Environmental Health Consultation Response

To	Amber Willard
Date	14-05-2026
Planning Ref	BR/71/26/PD
Site Description	78 Aldwick Road Bognor Regis West Sussex PO21 2PE
Date of Application	2026-05-08 00:00:00
Category	Permitted Development
Recommendation	No Objection No Objection – with conditions Objection Holding Objection

BR/71/26/PD

Proposed Ground Floor Plan

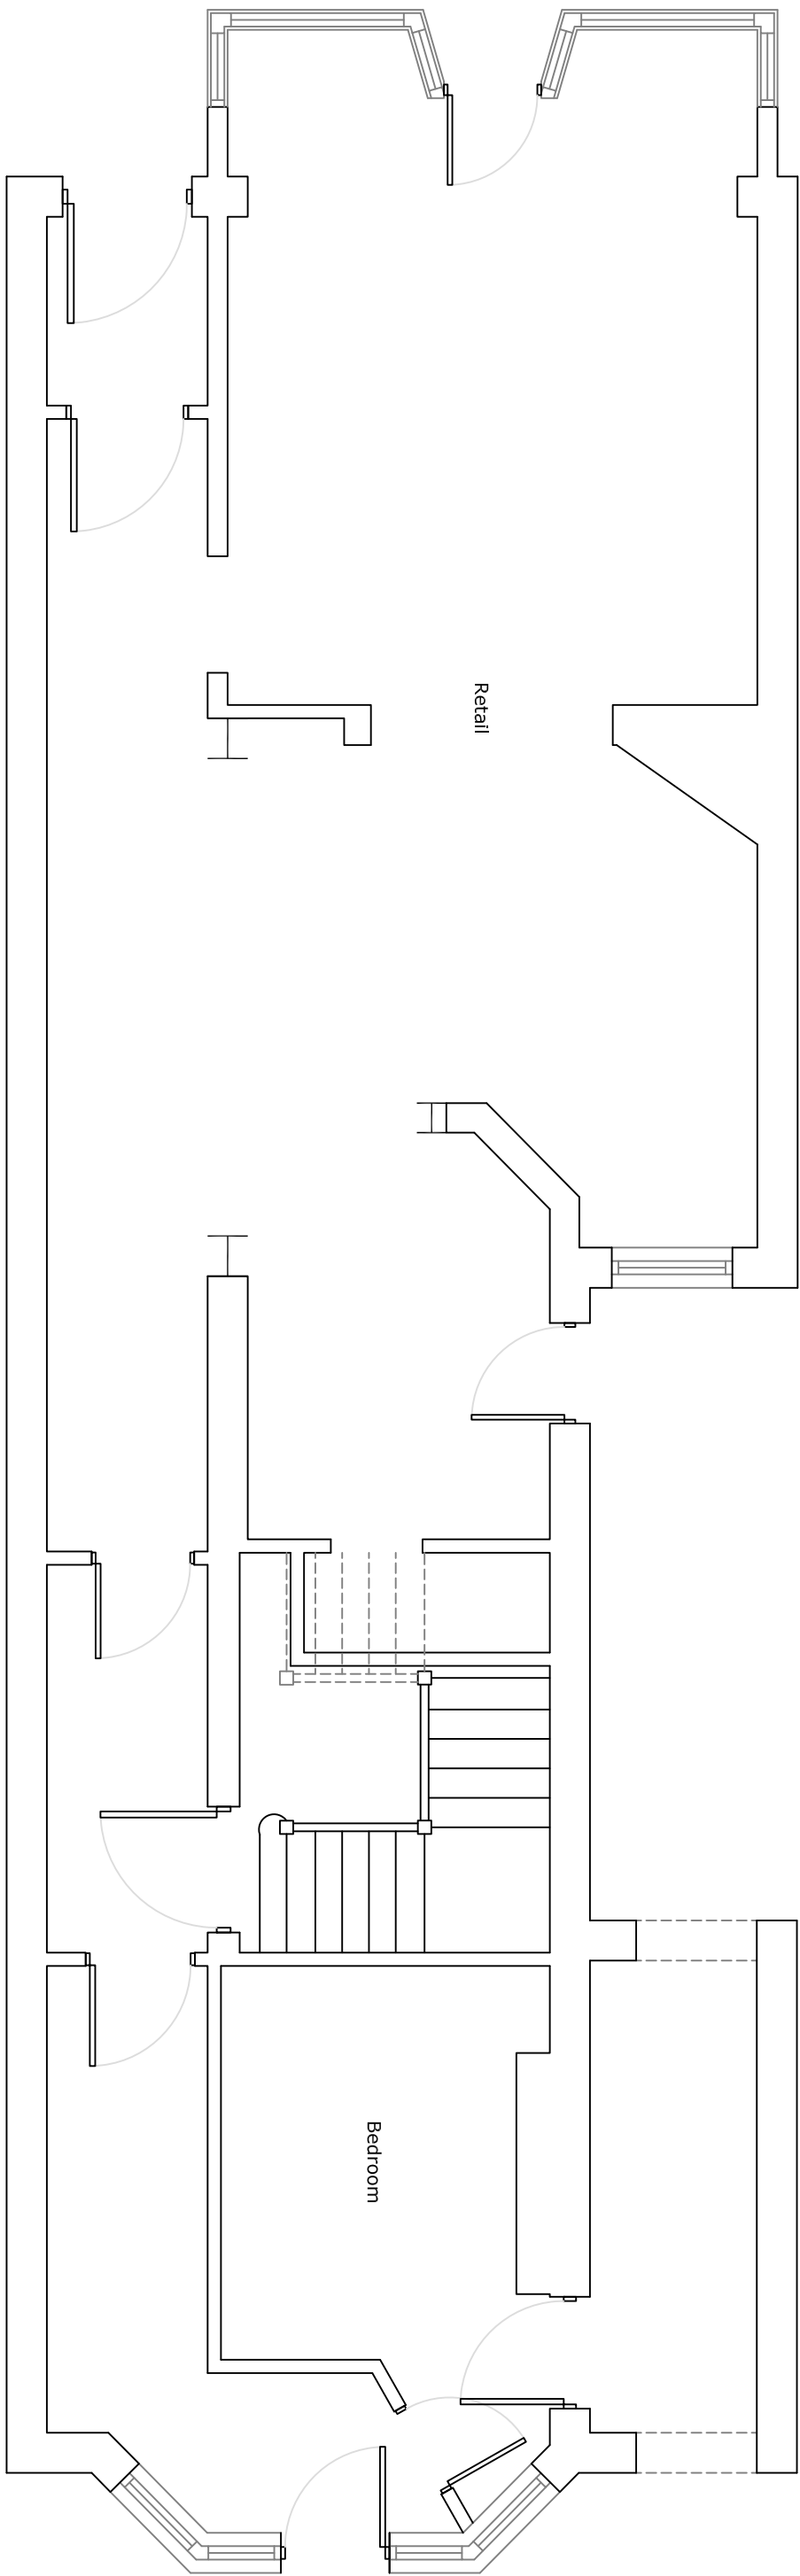
I have reviewed the above application and my only concerns is with the internal noise transmission from the commercial use to the new proposed residential accommodation, therefore I would recommend the following condition should consent be granted.

The change of use hereby permitted shall not begin until a scheme for protecting the new noise sensitive residential dwellings adjacent to the proposed commercial unit has been prepared by a competent person and submitted to and approved in writing by the Local Planning Authority. All works which form part of the scheme shall be completed before the development opens for business or the residential dwelling is occupied and retained and maintained in perpetuity. The scheme shall be designed to achieve a minimum airborne sound insulation value of 50dB (DnT, w + Ctr) for floors/ceilings and 48dB (DnT, w + Ctr) for walls.
